Application No: EP/68/21/HH
Site Address: Merrydown Kingston Lane East Preston BN16 1RP
Description of works: Erection of timber framed detached garage with ancillary accommodation on first floor, installation of electric gated entrance, erection of new brick garden walls and extension to existing driveway and hardstanding.

Thank you for your internet representation made on 13th July 2021 which has been recorded as an objection with the comments as follows:

East Elevation 1:50

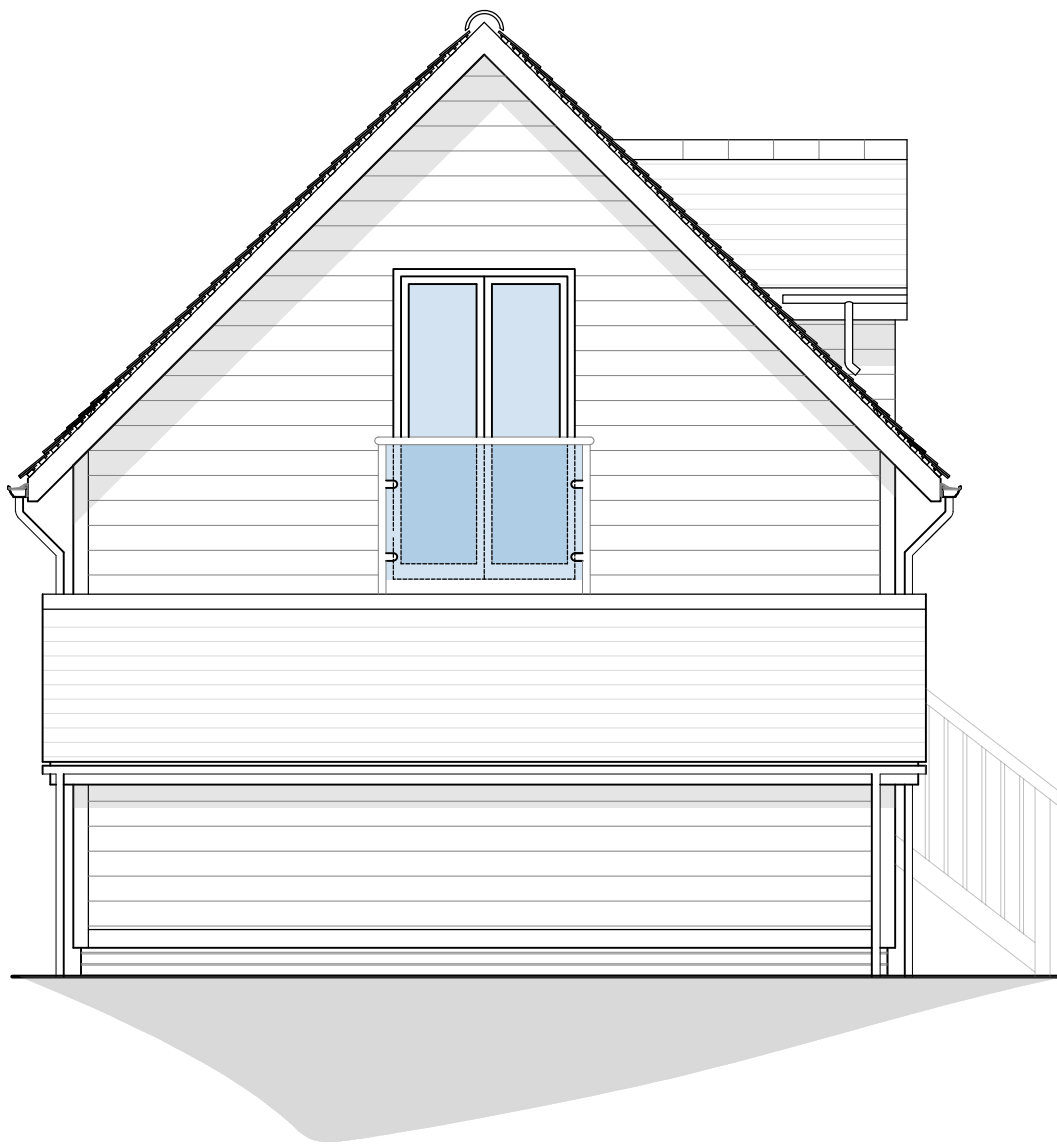
Proposed first floor accommodation may block views of open fields and tree lines from our house.
